SITE PLAN AND SUBDIVISION LEVEL III REVIEW (14-526): 72 Bishop
52,383 SF site; 21,374 SF building
30 efficiency units, 12 parking spaces
B-2c Zone

12 CONCRETE PAVERS
L5 NOT TO SCALE

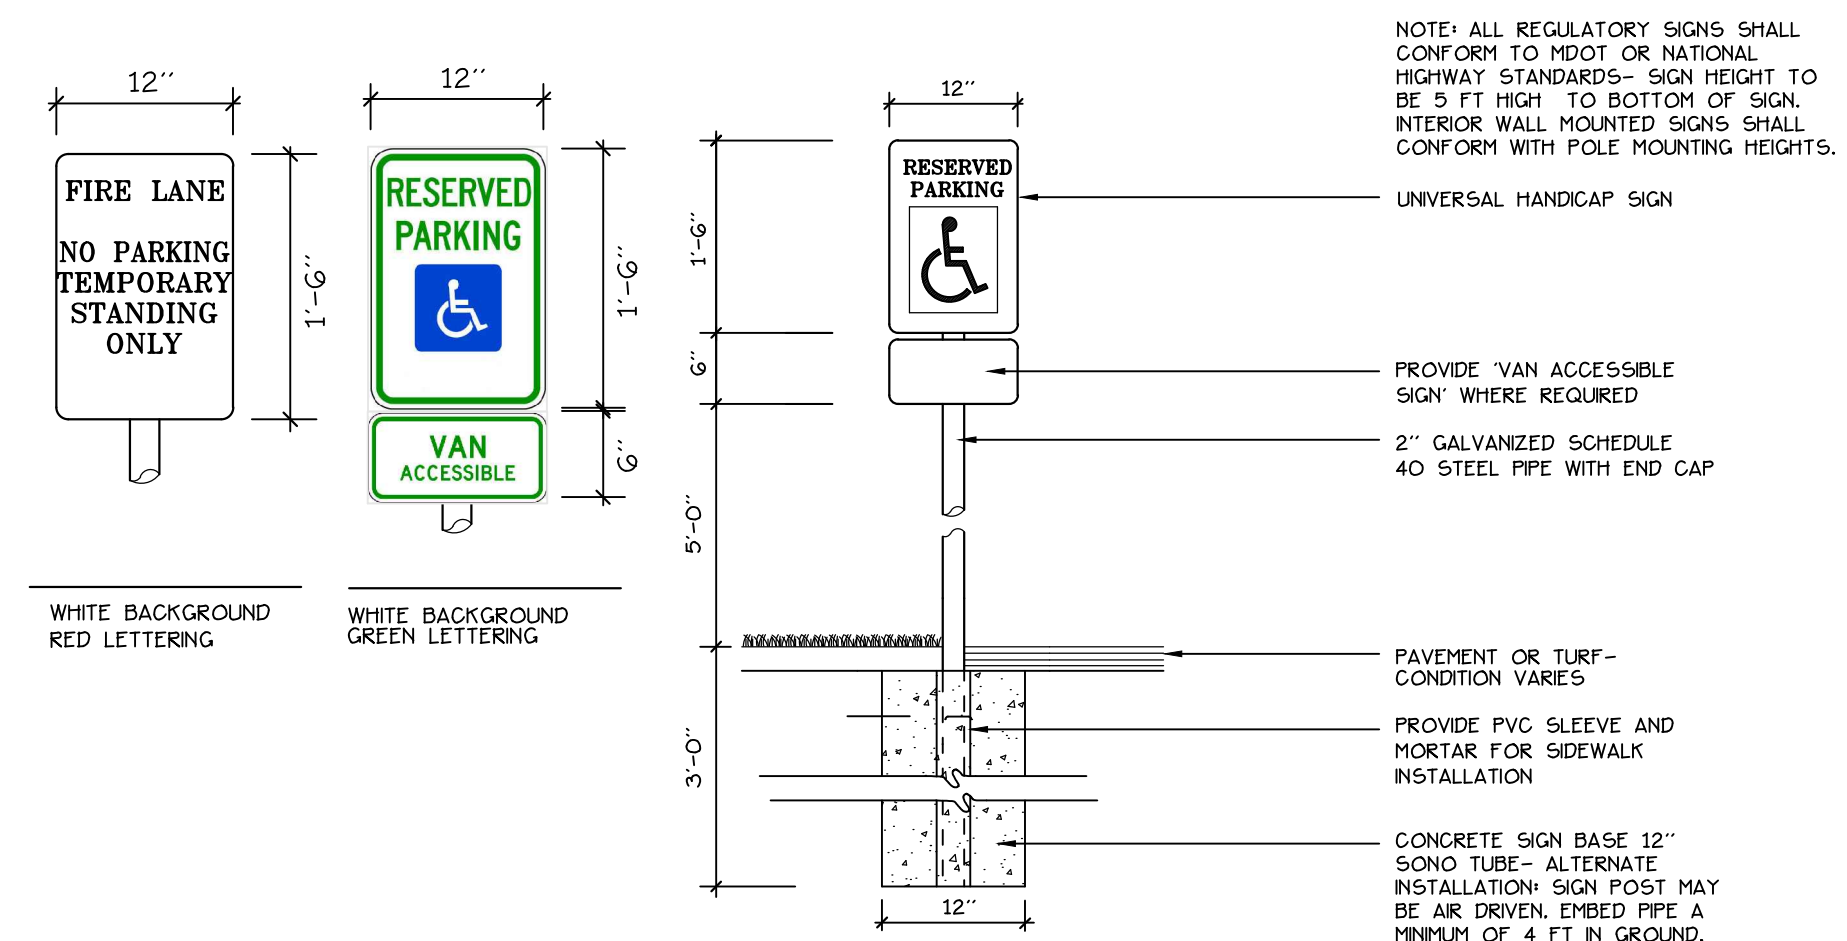
b. Access and Circulation	<ul style="list-style-type: none"> • Could striping in parking lot be replaced with pervious material?
	c. Public Transit Access	<ul style="list-style-type: none"> •

1 REDI-ROCK RETAINING WALL WITH GUARDRAIL
NOT TO SCALE

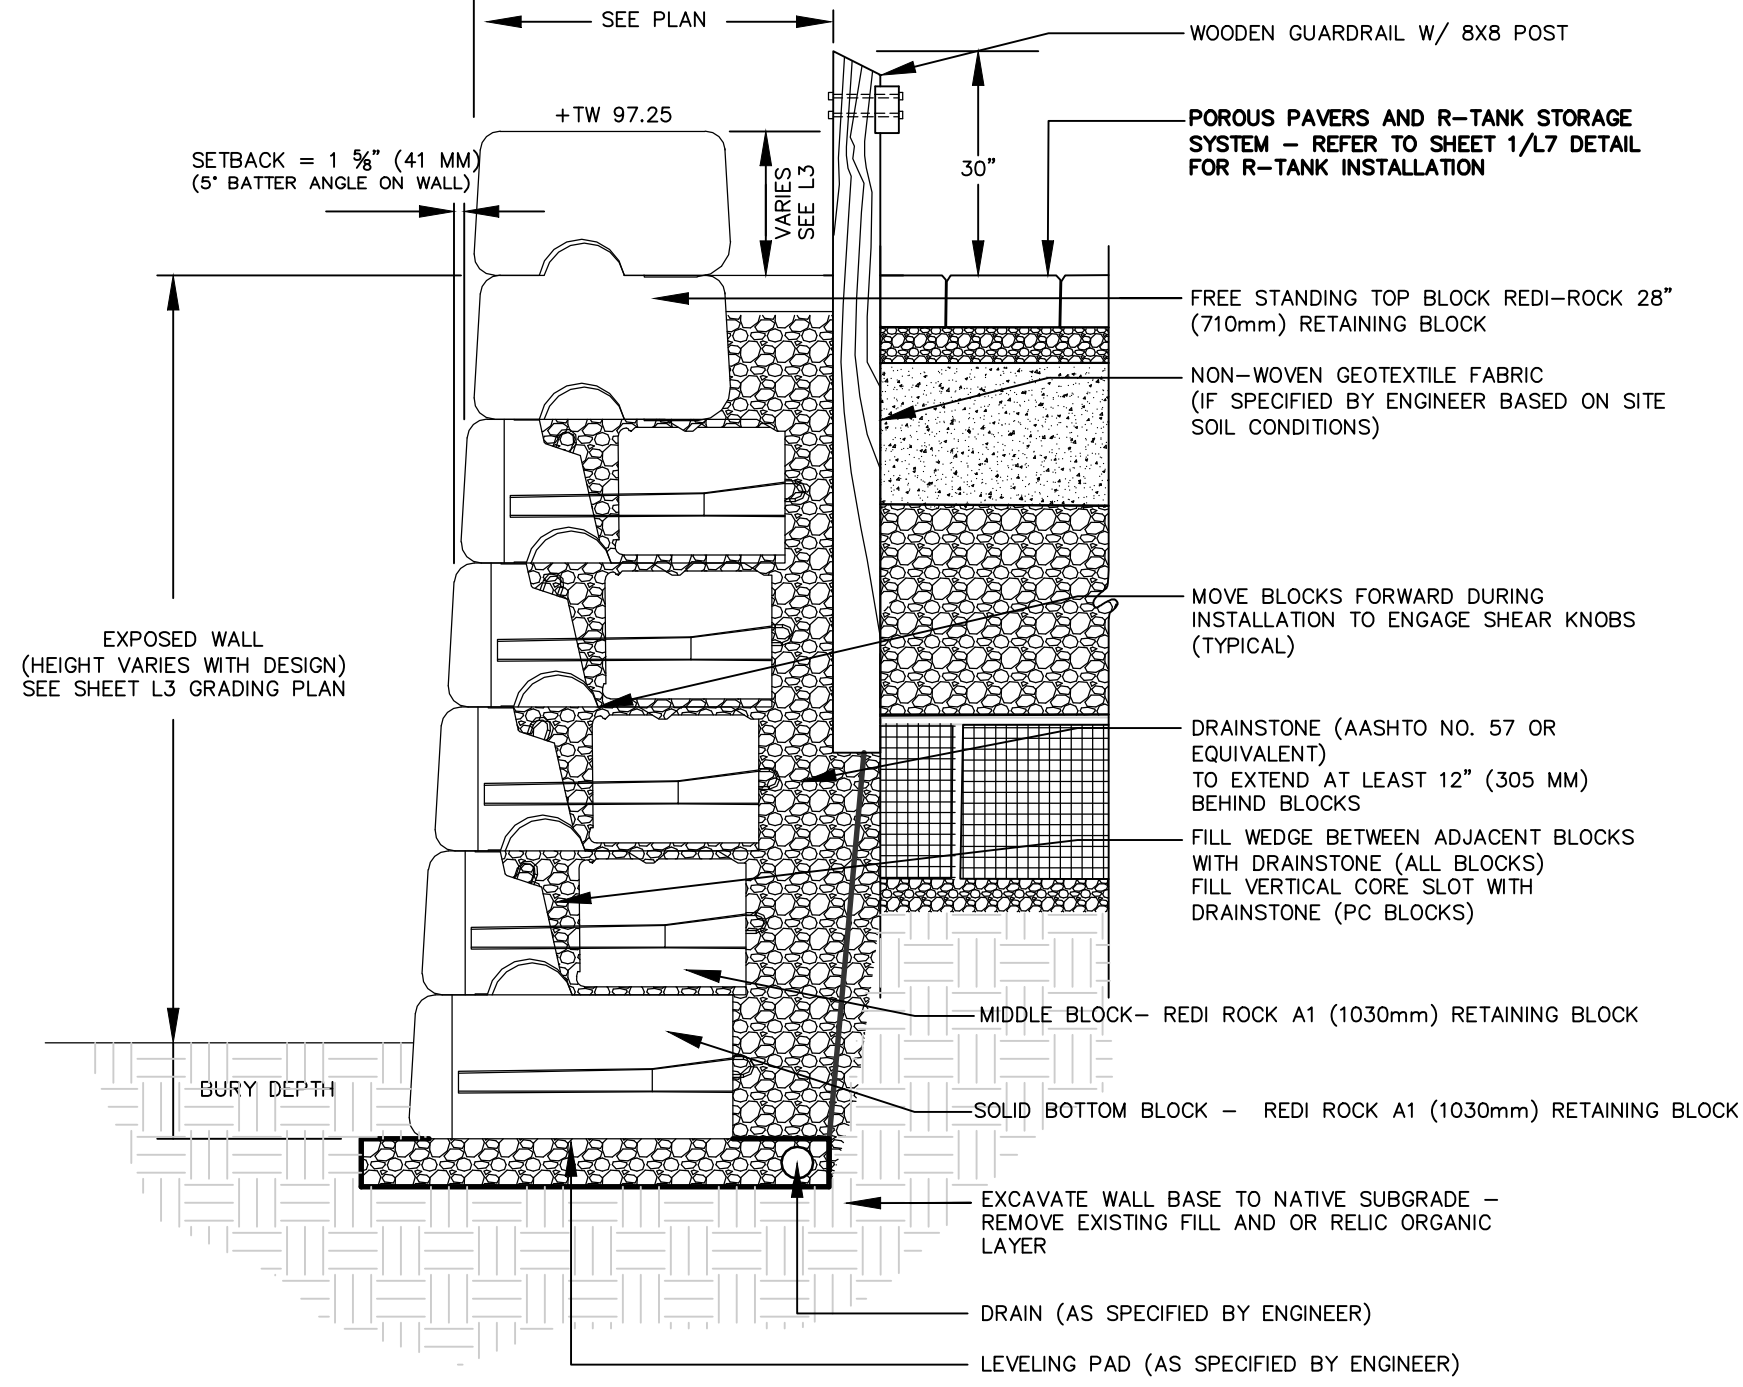
b. Landscaping and Landscape Preservation	<ul style="list-style-type: none"> • Are there trees in the setback on the Mason's side that are required to be preserved under 14-526 (min or 30% of existing trees 10 dbh or greater within setback should be preserved)? • Street tree standard for multi-family (TM 4.6.1):1 tree/unit in ROW (30 units = 30 street trees) Waiver request. Waiver language (14-526(b)2b(iii)(b)) qualifies planting w/in 10 feet of property line toward street tree requirement. Only one tree meets 10' setback. Add street tree to west of driveway entrance. • Understory plantings standard (14-526(b)2b(i)(b)): 6 shrubs (or ornamental grass)/45 LF of all frontages (50' in frontage line/45=1+*6=7) 25 provided. Could some of landscaping be moved/added to Bishop Street frontage? Along Mason's line? This area feels stark. • Provide details on fences and guardrail.
